Town & Country Planning (Control of Advertisement) (England) Regulations 2007 (as amended)

Application for Consent to Display an Advertisement(s)

Development: Installation of 1 No. internally illuminated fascia sign.
Location: Lidl Foodstore Oldlands Farm Steyning Way Bognor Regis PO22 9NN

PROPOSED SITE PLAN  
SCALE 1:500

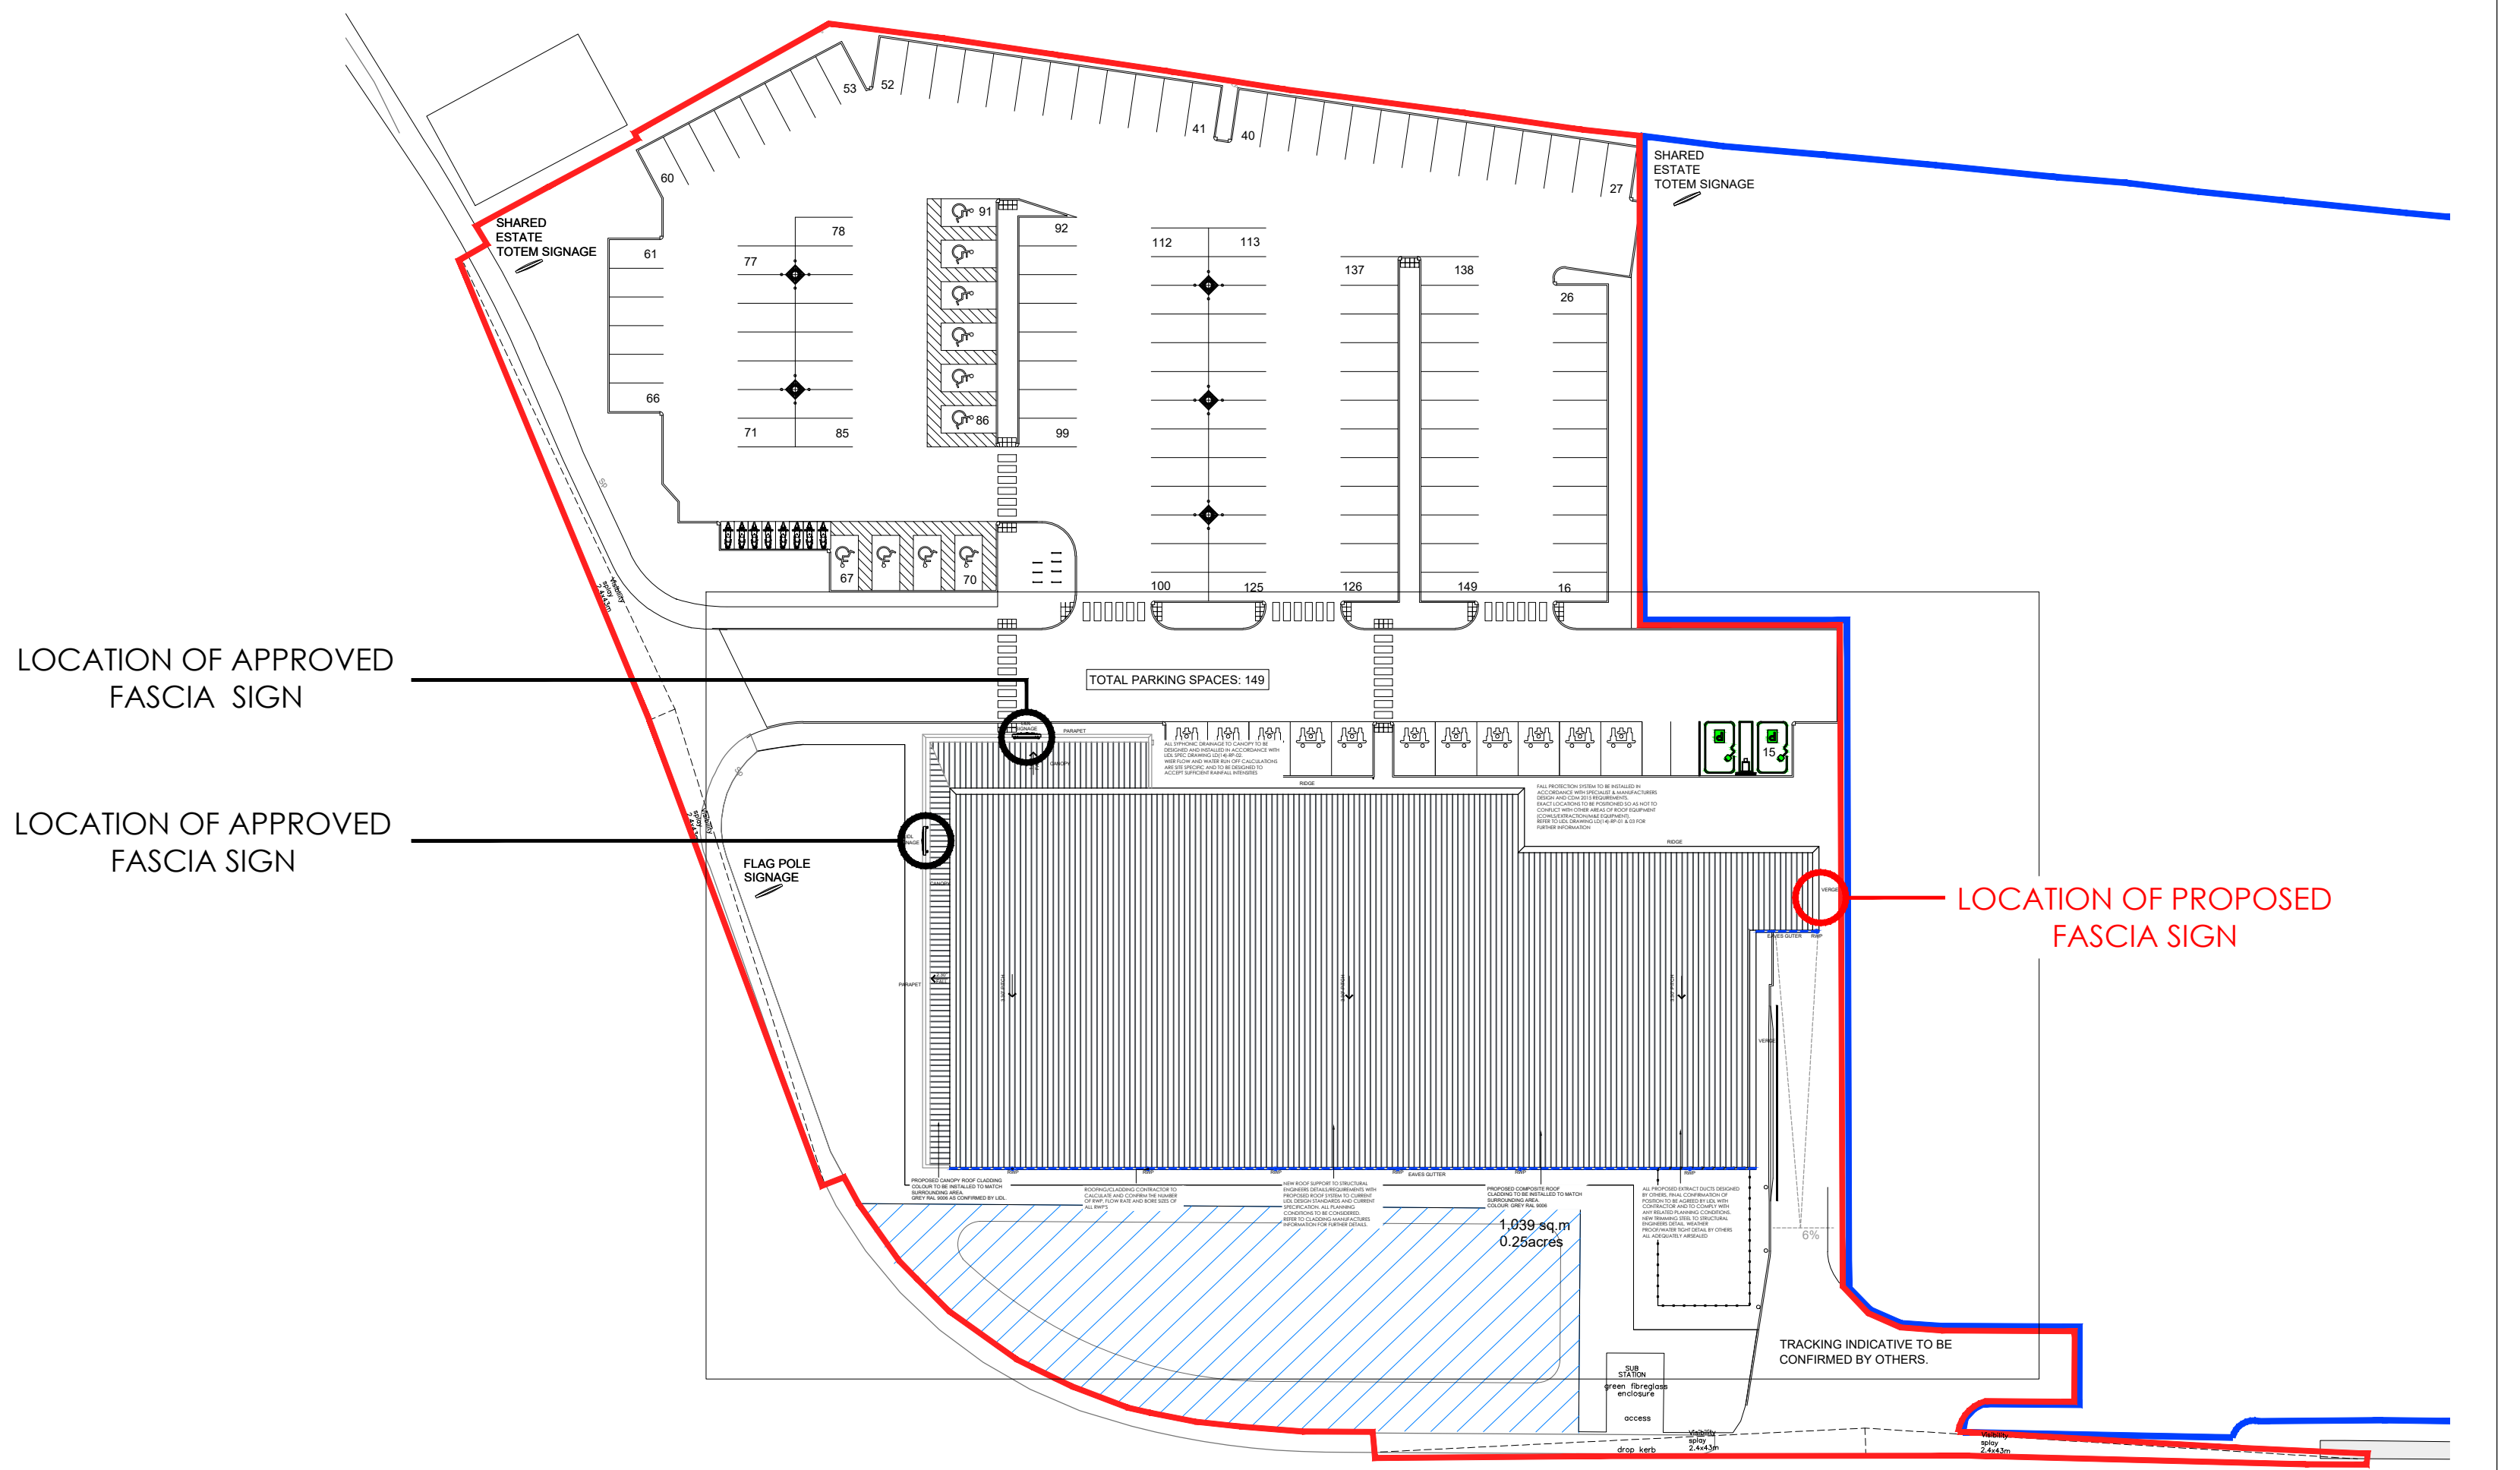
Please amend the submitted site plan to clearly show the 2 previously approved fascia signs and re submit.
